ESSENDON PARISH COUNCIL

REF:- Application no. S6/2011/0991/FP - 12 East View Essendon.

Drawing Title: Elevations		Client: Mr and Mrs David Wheatcroft 12 East View Essendon Herts AL9 6HJ	
Sheet No. 3	of 3	Drawing No:	12EV1-1
Drn: N.A.	Scale: 1:100	Revision: B	Original Drawing Size: A3
Date: May 2011

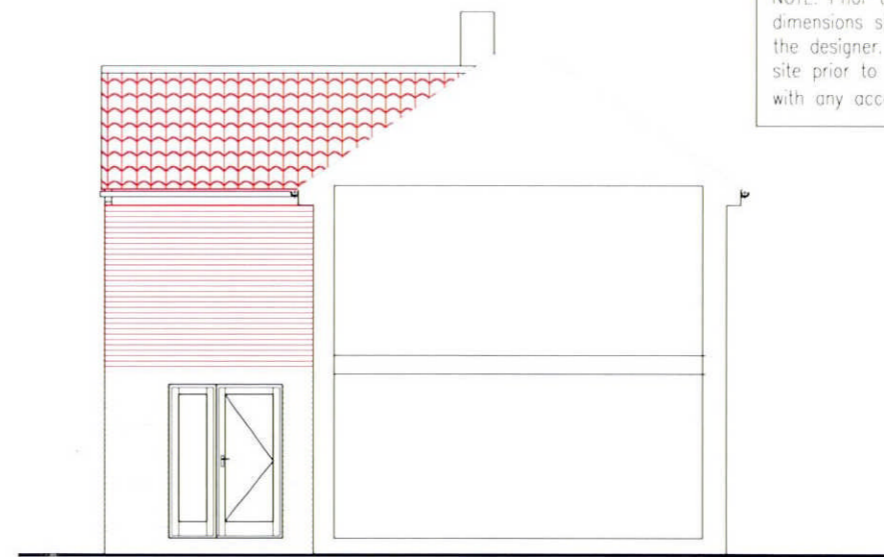
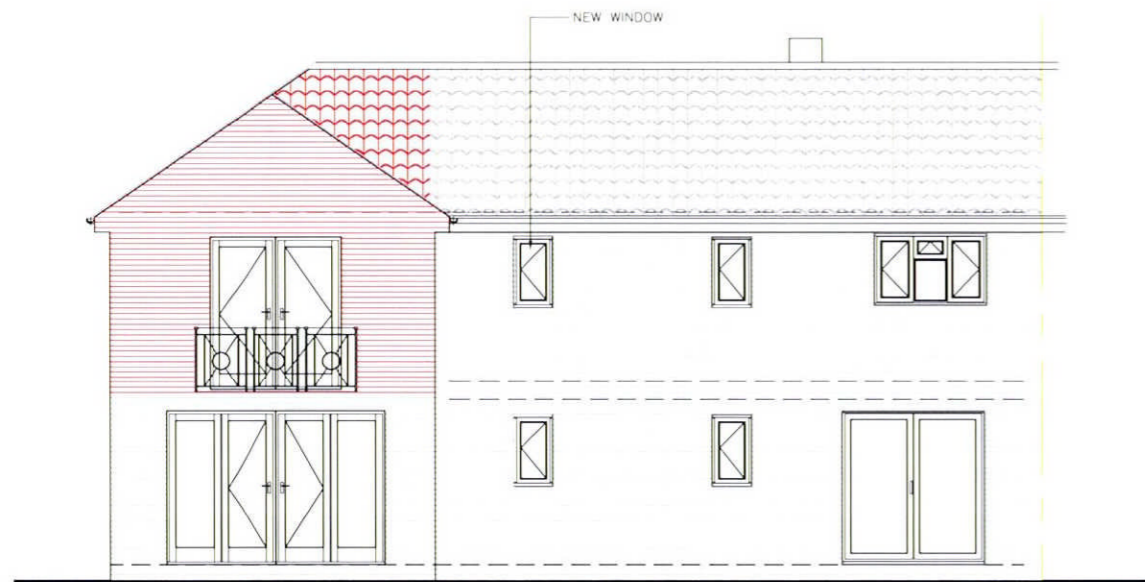
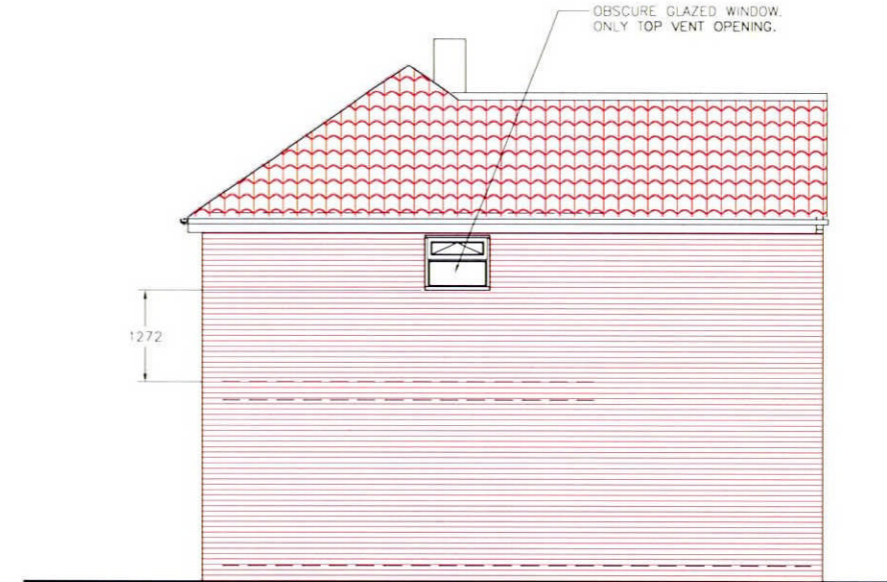
"Generally, most Councillors were content with the proposal. One councillor was concerned at the possible 'terracing' effect (particularly if the adjacent neighbour also builds a two storey extension) and the loss of relieving view to the countryside beyond. Bathrooms should have obscured glazing.
